Engineers Comments Regarding Surface Water Drainage

Application Reference:	WA/28/26/DOC	Reviewer Reference:	ADC/EXT5/AF
Planning Officer:	Amber Willard	Date of Review:	22/06/2026
Site Name:	Stoneybrook Farm Eastergate Lane Walberton BN18 0BA		
Application Description:	Approval of details reserved by condition under WA/108/24/PL relating to condition 3- Surface Water Drainage.		
Assessment Number:	2

Application Reference: WA/28/26/DOC Site Name: Stoneybrook Farm Eastergate Lane Walberton BN18 0BA	Initial Issue Date: 30/04/2026 Issue Date: 22/06/2026 Reviewer Reference: ADC/EXT5/AF
---	---

Front Elevation - Basin Headwalls

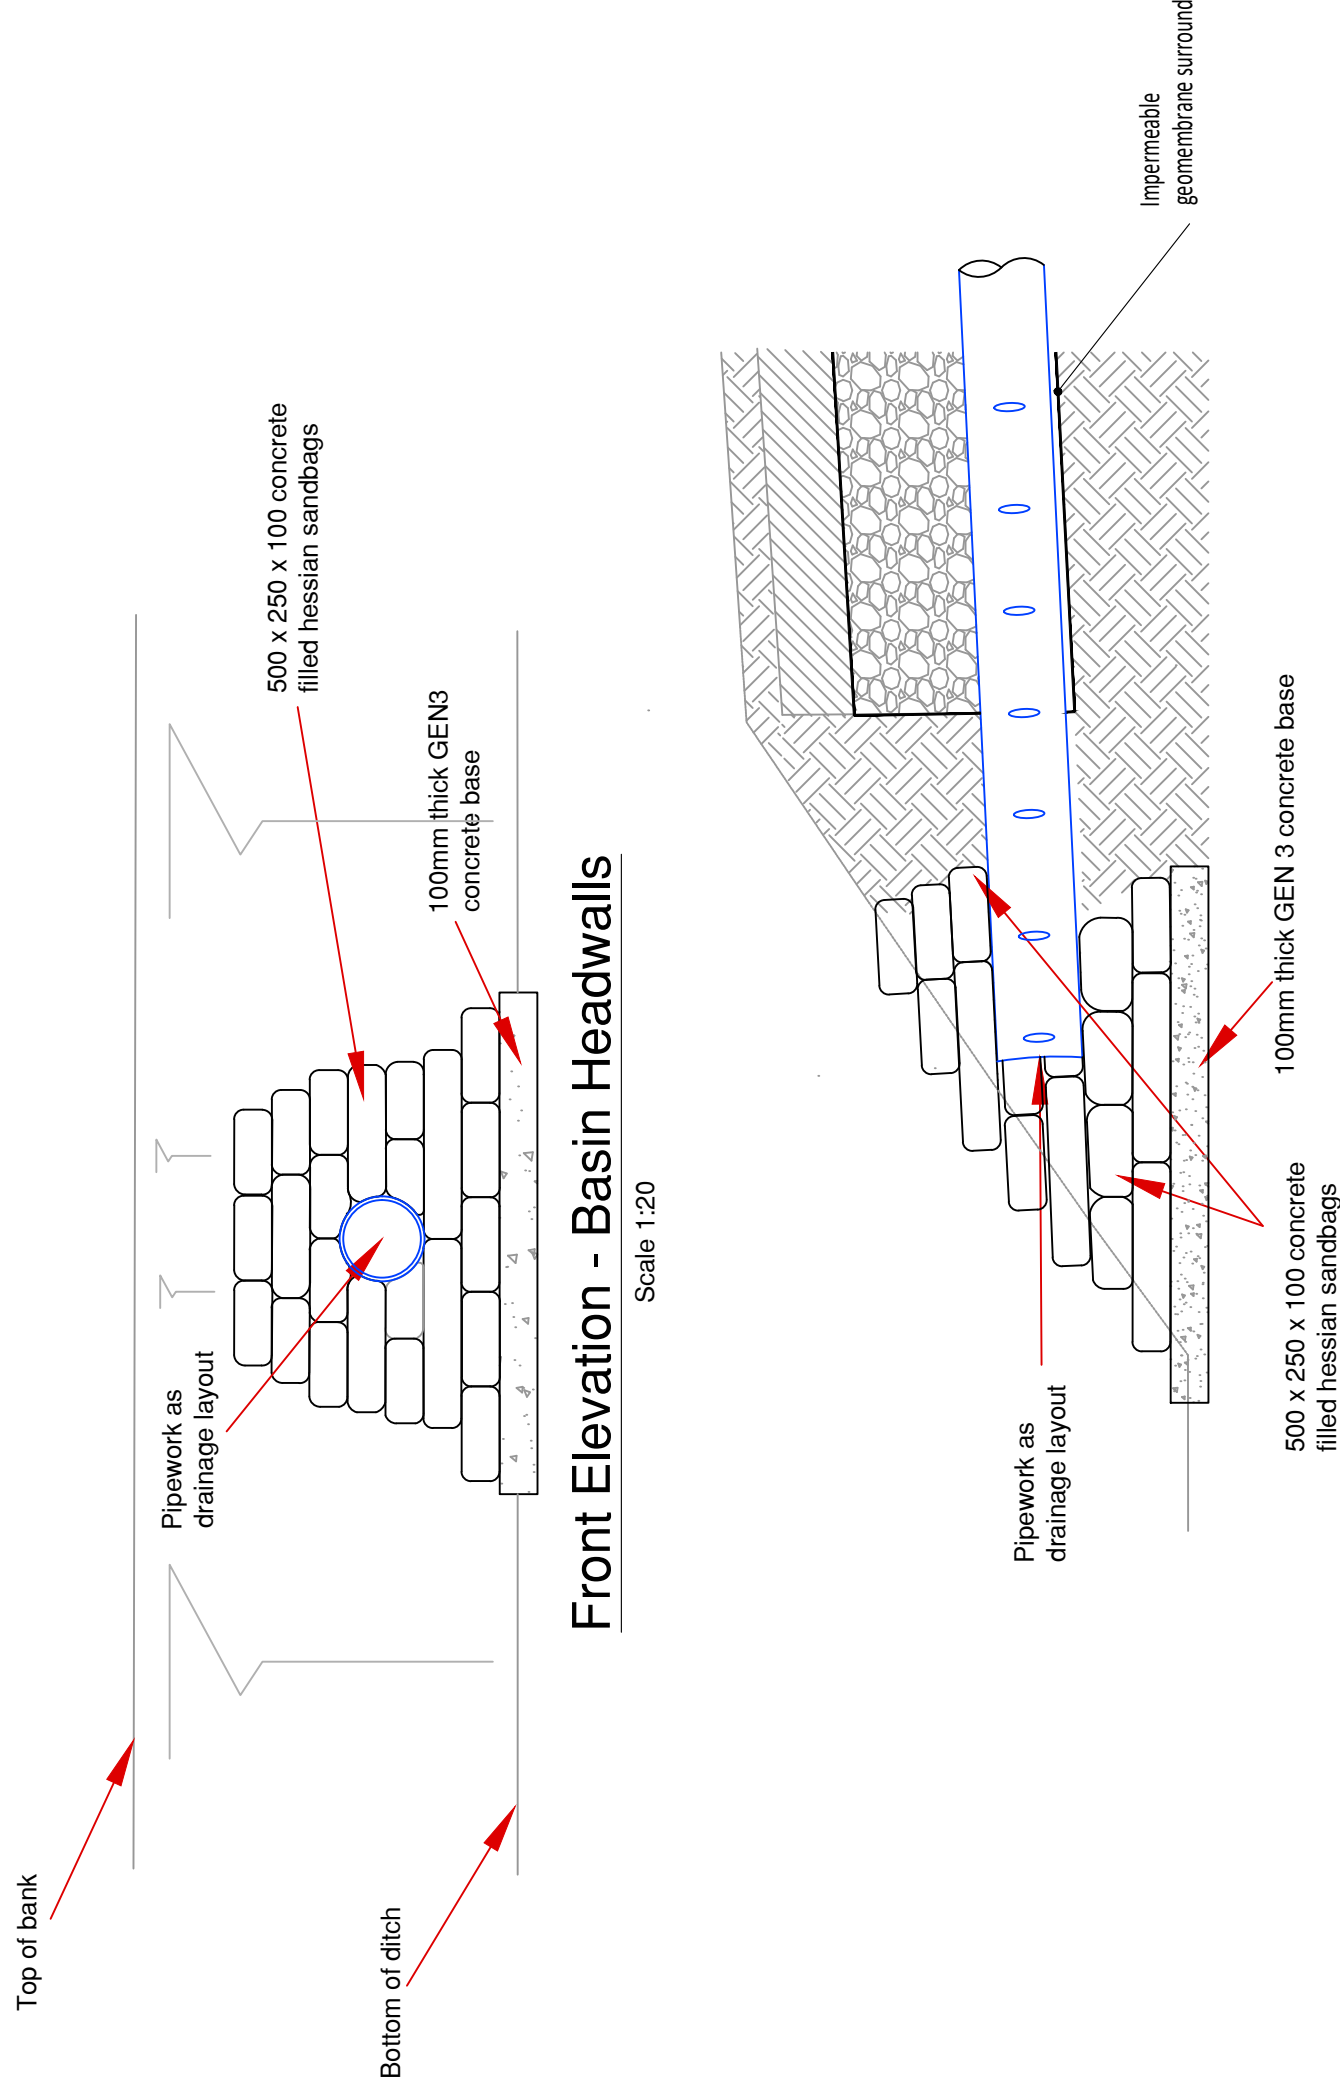
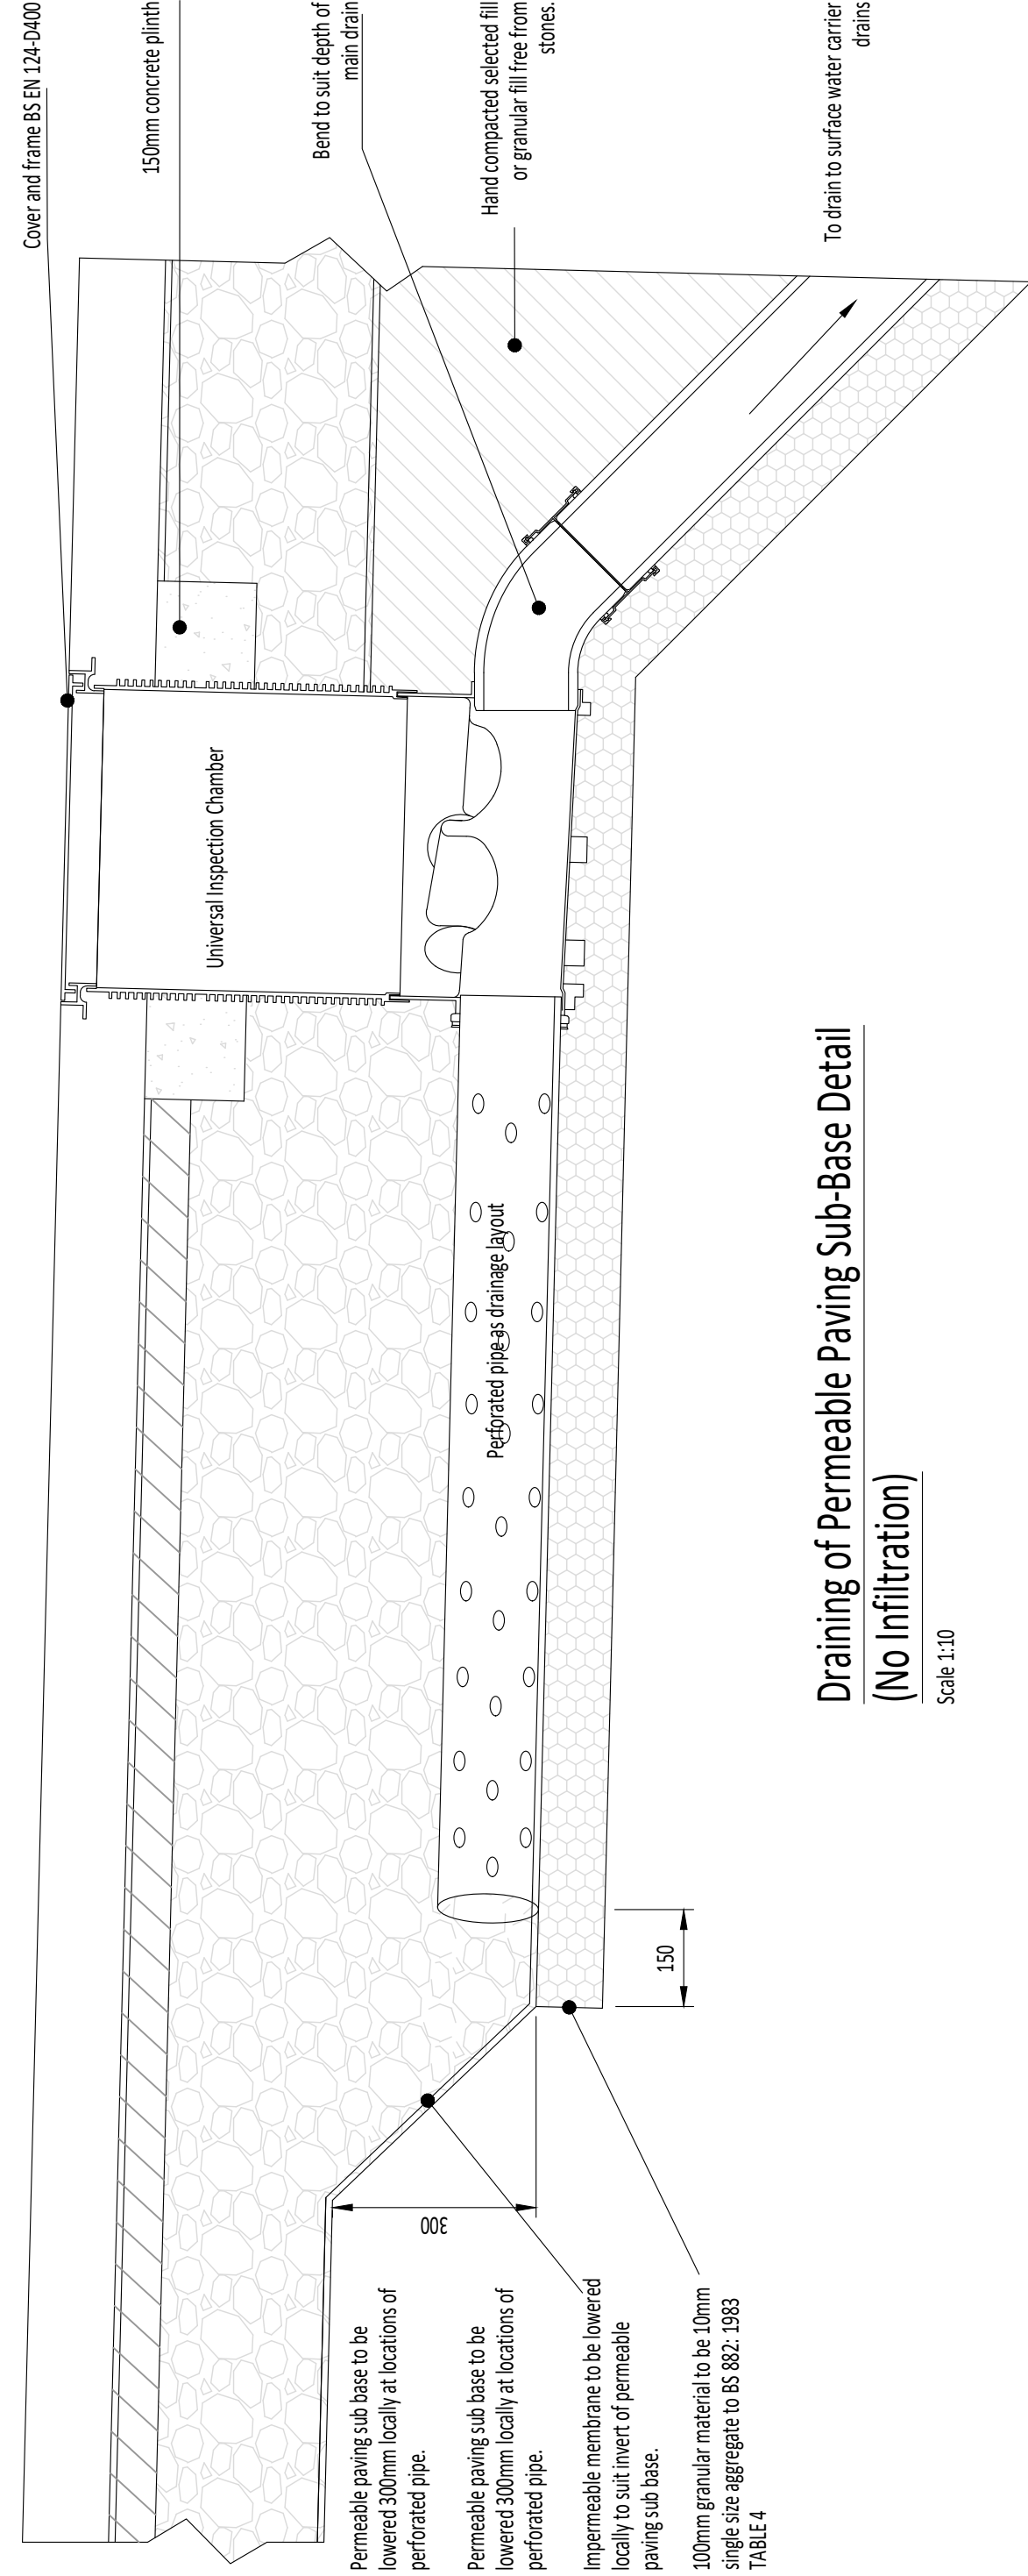
7.	Measures to mitigate blockage of the flow control device should be incorporated at the basin headwall and flow control chamber.	Gabion cage is proposed in front of the outlet headwall to provide a filter process and remove debris that could cause blockages. Construction detail provided.	The gabion inlet provides suitable blockage reduction from the open feature. Details should be provided for the flow control chamber to include blockage protection.

Section C-C
Scale H 1:250
V 1:50

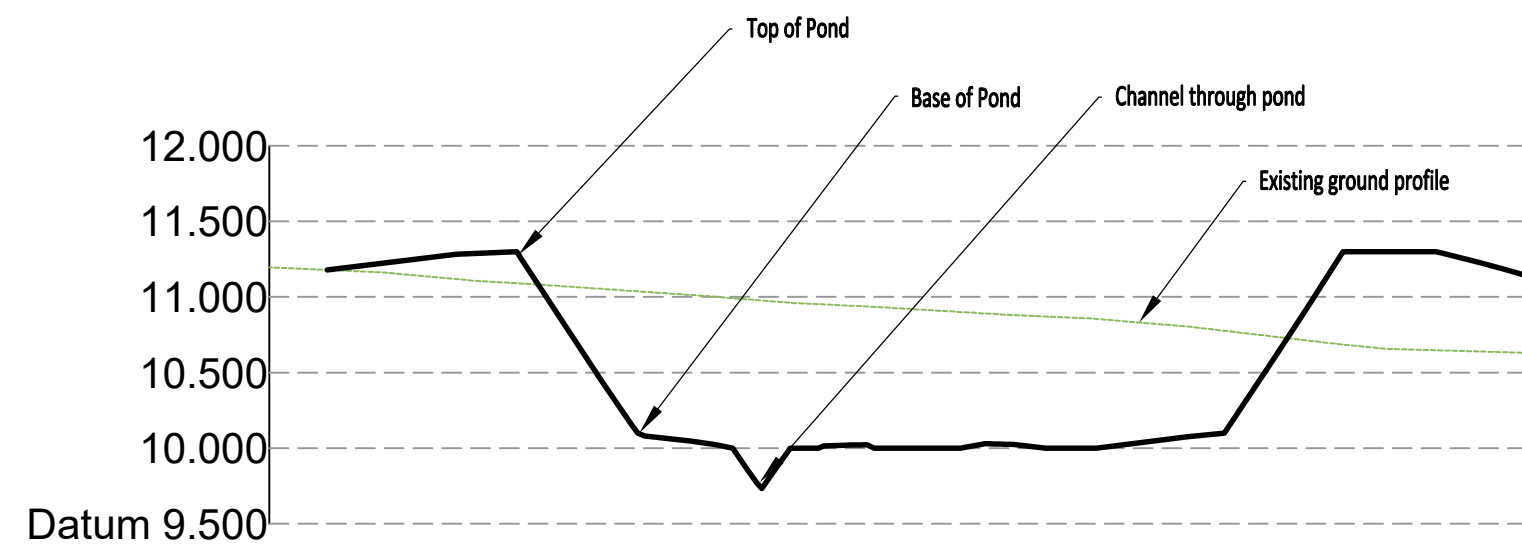
10.	The surcharged outfall should be clarified in the calculations.	A surcharged model has been provided with the groundwater set at 10.333m	A surcharged level should be specified at the outfall for the duration of the design storm. This should can be based upon the national surface water flood modelling or a robust estimate of water levels in the watercourse.
